ASSESSMENT REPORT

Section 96(1A) Modification Kings Park Metal Recovery (SSD 5041 MOD 1)

PROJECT COMMERCIAL INDUSTRIAL BUILDINGS						
23-43 + 45 Tattersall Road, KINGS PARK NSW 2148						
TITLE COMBINED SITE PLAN						
FIRE HYDRANT & WATER CANNON SYSTEMS						
DWG. SIZE	SCALE	PROJECT NO.	JOB NO.	REV.	DWG. NO.	
R1	NTS	14 023	16-001	P4	FH-01

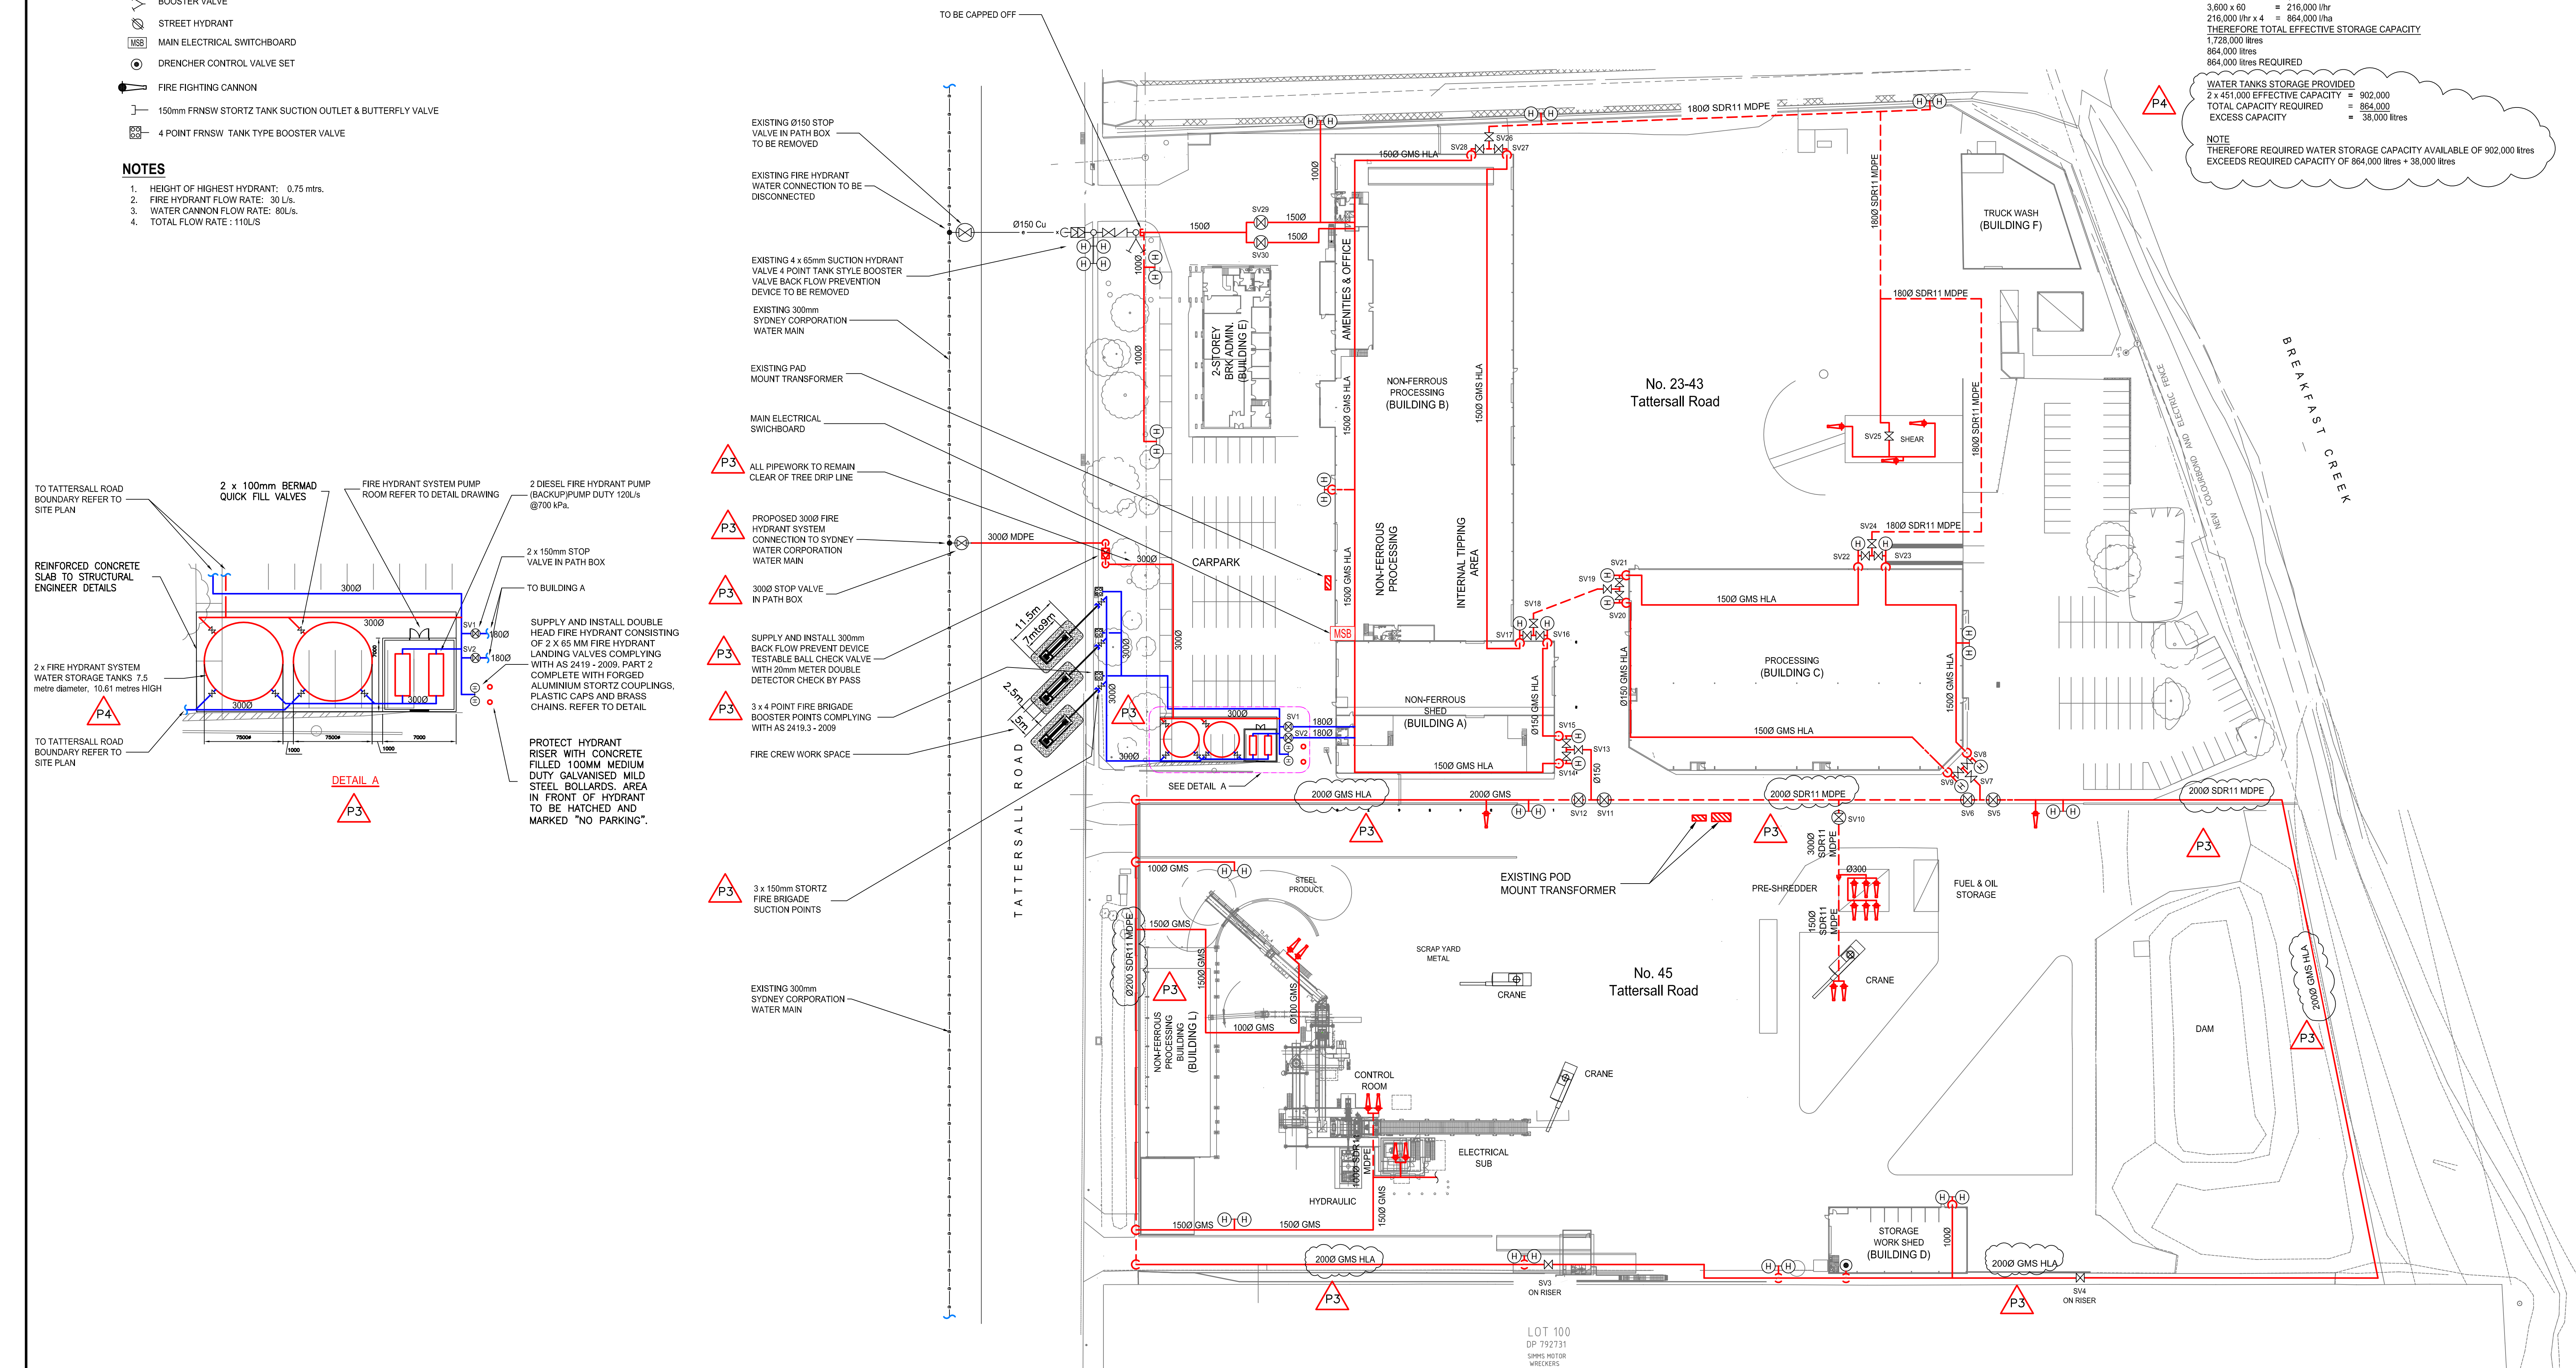
FRNSW did not object to the modification. FRNSW had concerns with the existing fire safety measures in place at the site and therefore provided requirements for crucial upgrades, alterations and consultation including:

- upgrade of existing Ordinance 70 fire hydrant systems to meet the National Construction Code (NCC);
- the use of a single fire hydrant system as opposed to separate systems for each lot. The use of two hydrant systems for one facility is problematic in respect to effective incident management;
- water supply capability;
- requesting the final design of the hydrant system be developed in consultation with and to the satisfaction of FRNSW;
- protection of floc storage area with a sprinkler system and smoke detection system;

- separate fire hydrant systems: to facilitate the amalgamation of the two fire hydrant systems, FRNSW recommend the consolidation of the two allotments on one title;
- fire hydrant water supply capability: the NCC in clause E1.10 includes provisions for special hazards which require suitable additional fire safety provisions. FRNSW believes the facility is captured under this clause and as such recommends the sites fire water demand be determined in consultation with them; and
- floc storage area sprinklers and smoke detection systems: FRNSW reiterated that these systems are required to be implemented at the site.

On 27 April 2017, FRNSW provided a further submission which reiterated their position that the facility should be considered a special fire hazard site in accordance with E1.1 of the NCC. FRNSW also provided details of an additional large metal fire which occurred on 24 April 2017 at the facility which required an extensive commitment of resources to achieve fire containment and extinguishment. FRNSW suggested that the difficulties faced by fire fighters, the amount of resources exhausted and the length of time it took to extinguish the fire strengthens their argument that the site poses a special fire hazard requiring the additional measures to be installed.

On 18 April 2017, the Applicant provided a response to FRNSW subsequent submission in which the Applicant again questioned FRNSW's requirement to utilise a single hydrant system for the site and ensure the water supply capability of the hydrants meets the hazard potential of the facility. The Applicant did however agree to install a sprinkler system and smoke detection in the floc storage area.

In an additional response, the Applicant provided a flow rate and pressure test indicating the target demand required by FRNSW could be met at the site. The Applicant also agreed to upgrade the sprinkler system and install a smoke detection system in the floc storage area. However, the Applicant questioned whether the additional fire safety measures required by FRNSW could be required as conditions of consent as part of this section 96(1A) modification application as they believe there is no nexus between the amendments proposed and the required fire safety measures. The Applicant argues that the fire safety measures required by FRNSW relate to the entire site and the proposed modification only relates to minor alterations to part of the site.

Drawing Name:
Landscape Masterplan

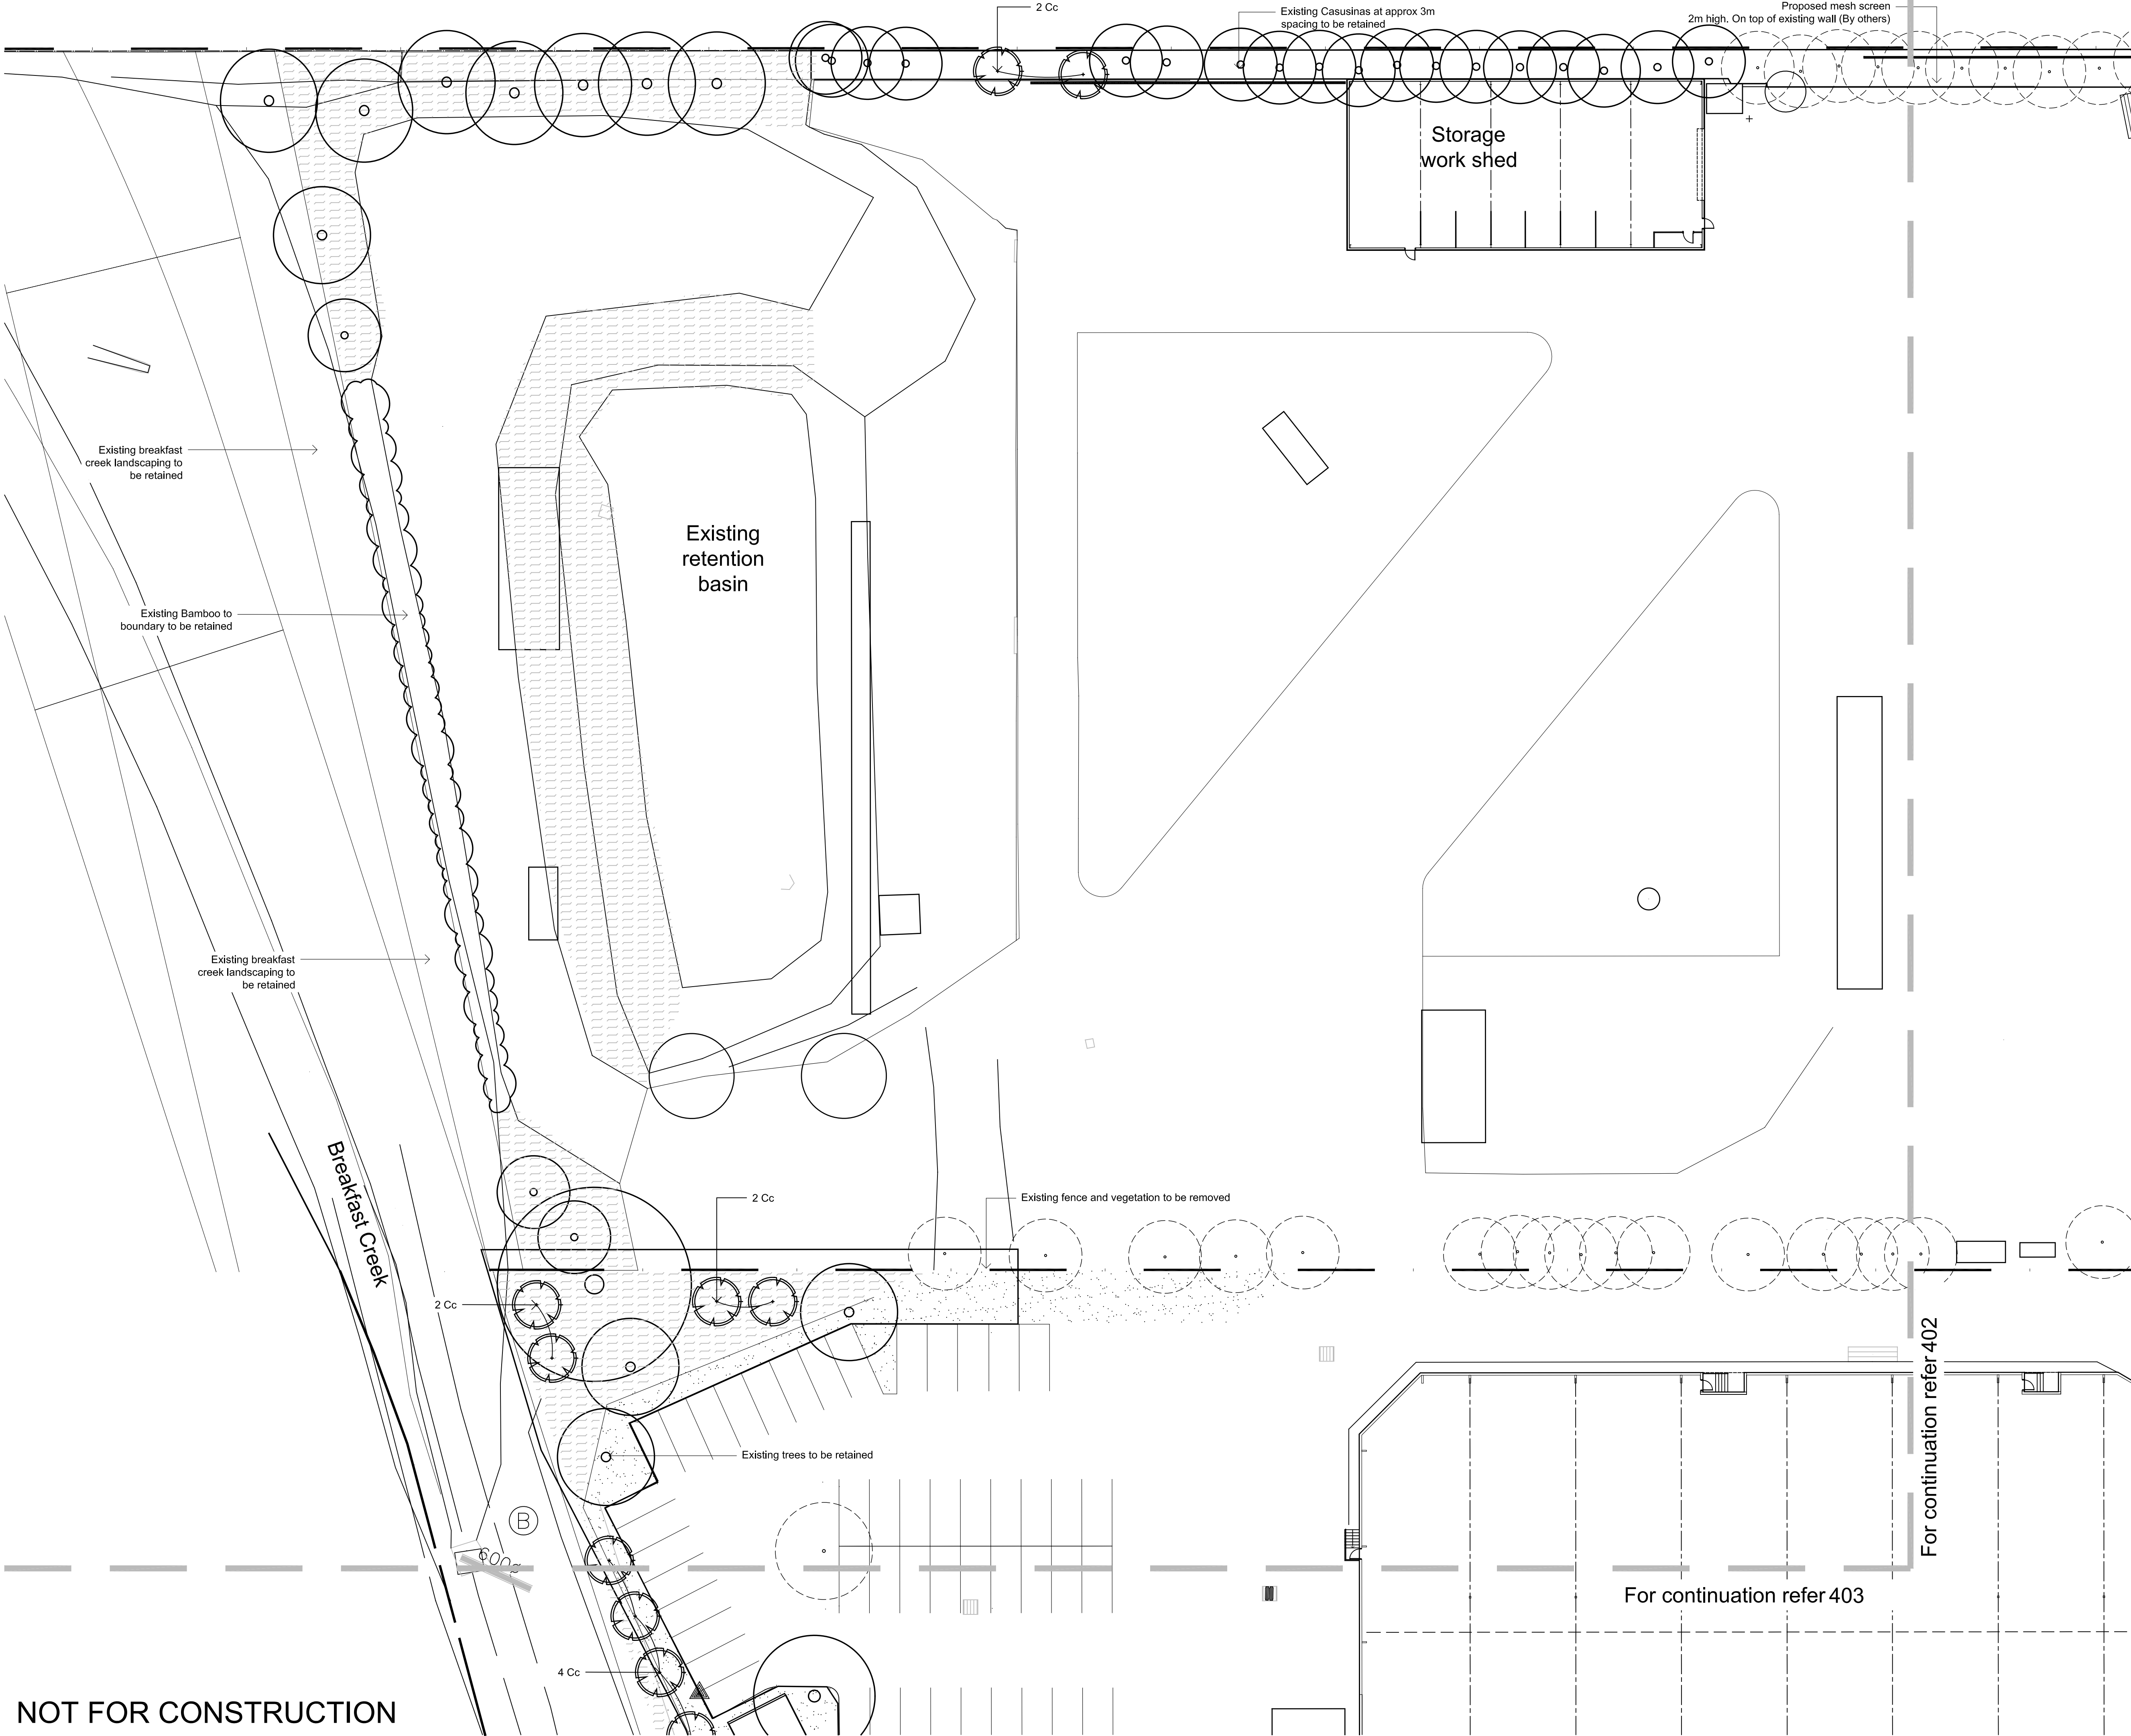
The Applicant's response was sent to the EPA, Council and FRNSW for comment. The EPA reiterated that it had no objection to the modification and had no further comment. Council advised the majority of its comments had been addressed and requested that additional tree plantings be required at the Tattersall Road frontage and the existing shade cloth be replaced.

Council reviewed the Applicant's submission report and suggested additional trees be planted at the street frontage and the existing shade cloth atop the acoustic wall be replaced. The Applicant, in response, provided revised plans to indicate the shade cloths will be replaced and additional plantings will be provided.

In response to Council's subsequent submission, the Applicant provided updated plans and elevations on 27 January 2017 which show additional tree plantings at the Tattersall Road frontage and the replacement of the shade cloths.
